KITTITAS COUNTY COMMUNITY DEVELOPMENT SERVICES

January 12, 2015

RE: Grow Bros SEPA, SE-14-00011

The application for multiple buildings for I-502 purposes, on Radar Road located to the North of the city of Kittitas, which is zoned Agriculture 20, located in a portion of Section 15, T18N, R19E, WM, in Kittitas County. Kittitas County Community Development Services (CDS) will need the following information to continue processing the application:

This page shows you how the fence will lay out in the existing parcel with all the correct setbacks

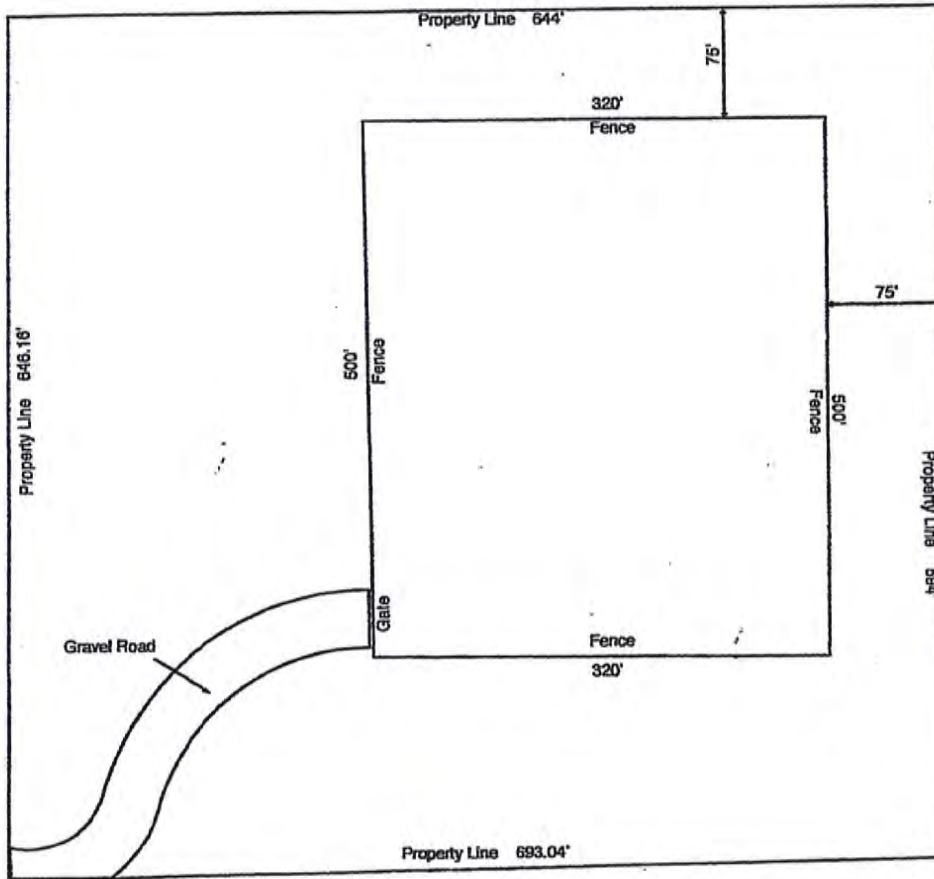
1. CDS is in receipt of the additional information submitted on January 7, 2015. After review of said additional information with regards to the original application there is a discrepancy. Within the SEPA checklist Question A. Background number 11. *21.12 acres, I-502 grow facility. (8) 30' x 80' greenhouses, with (2) 8' x 20' storage structures, (20) 10x 12' portable starter structures, an office and a 10 x 12' security building.* & the site plan submitted as requested by CDS shows double what is stated. CDS will need the applicant to either amend the site plan or Question A. Number 11 of the SEPA checklist for consistency.

Plant Spacing & Irrigation Description

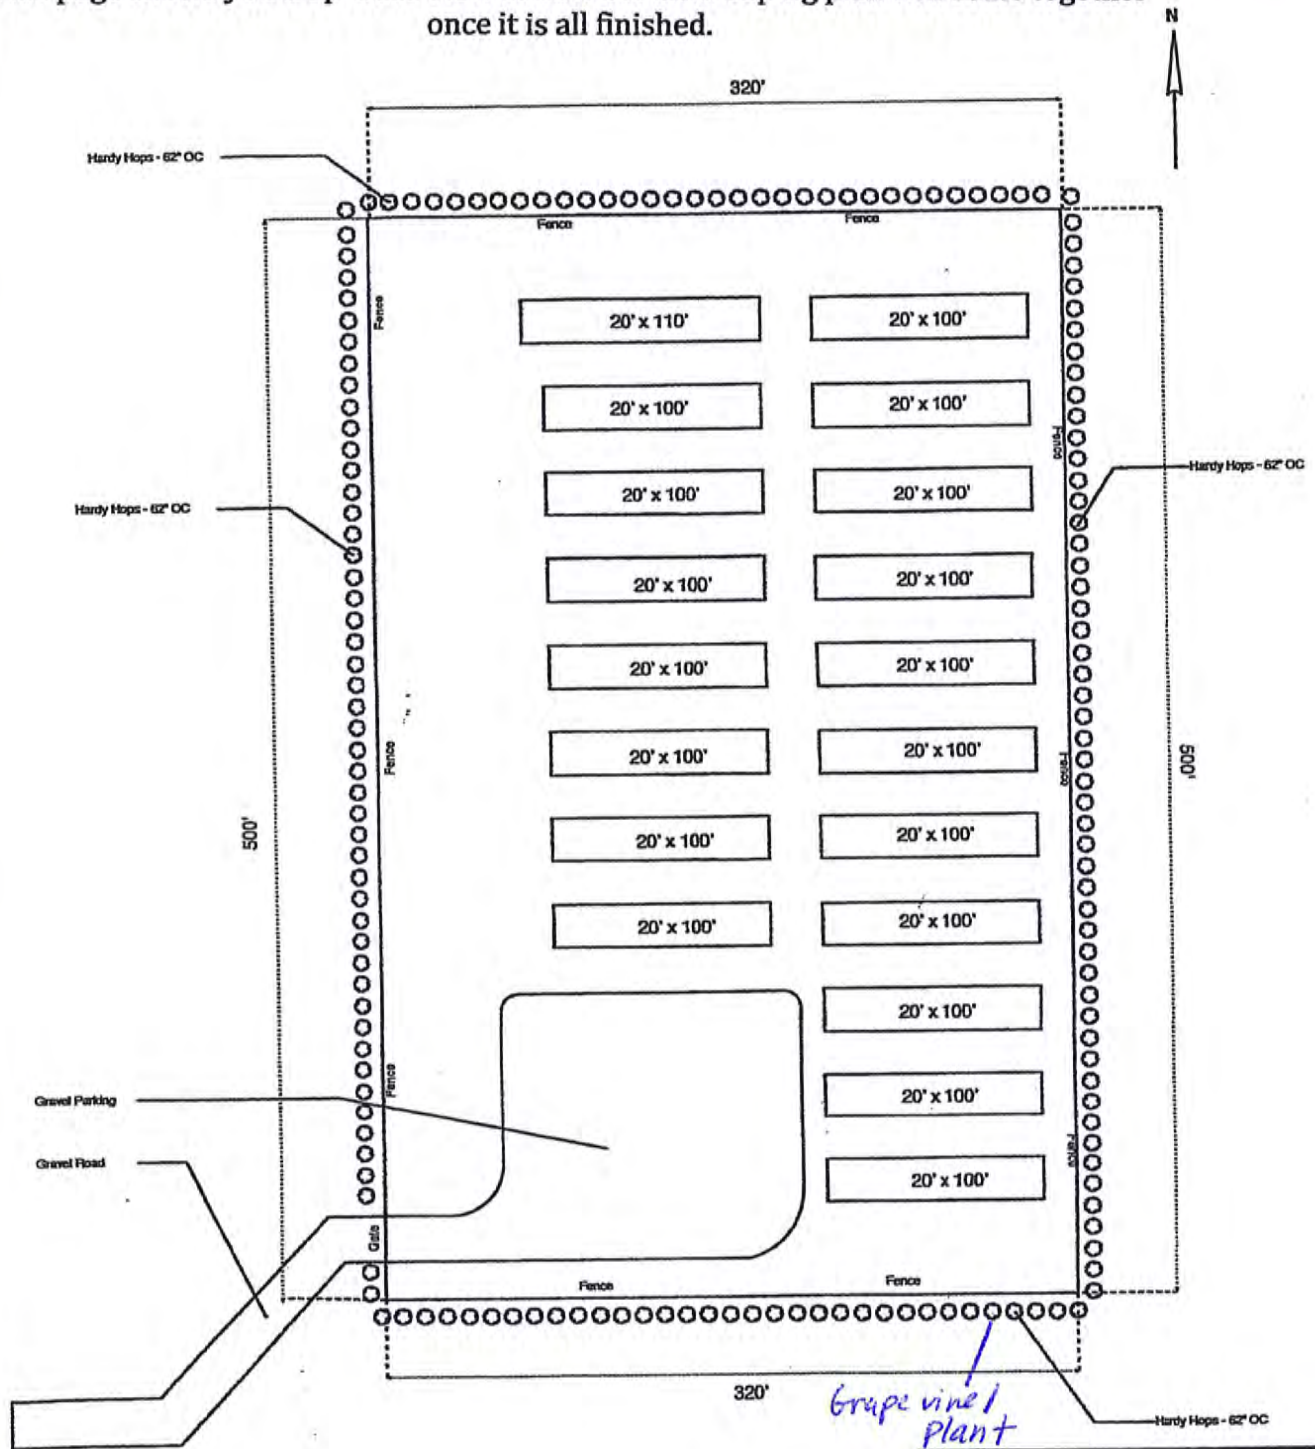
3. Clarification on question B. Environmental Health Section 4. Sub section d. Proposed landscaping, use of native plants, or other measures to preserve or enhance vegetation on the site, if any: *Hops planted at fence perimeter, 62 inches on center for sight obscuring.* In regards to this question is the landscaping plan turned in to CDS on November 21, 2014, see attached documents, for BP-14-00772, fence permit stating that there will be alternating hops and grape vines/plants totaling 166 plants, apply to this question?

Thank you for this opportunity. We will provide and install 166 Hardy Hops ("Humulus lupulus") on 62" centers in 1 gal containers. This project is set to start in the beginning of April. Humulus lupulus is planted soon after the last frost. This is to insure that the new plants will grow a significant healthy root system. A healthy root system will insure the vines live over the harsh winter. The fence behind the row of plants will be a great way for them to climb and be strong. This foliage can reach heights of 18 feet.
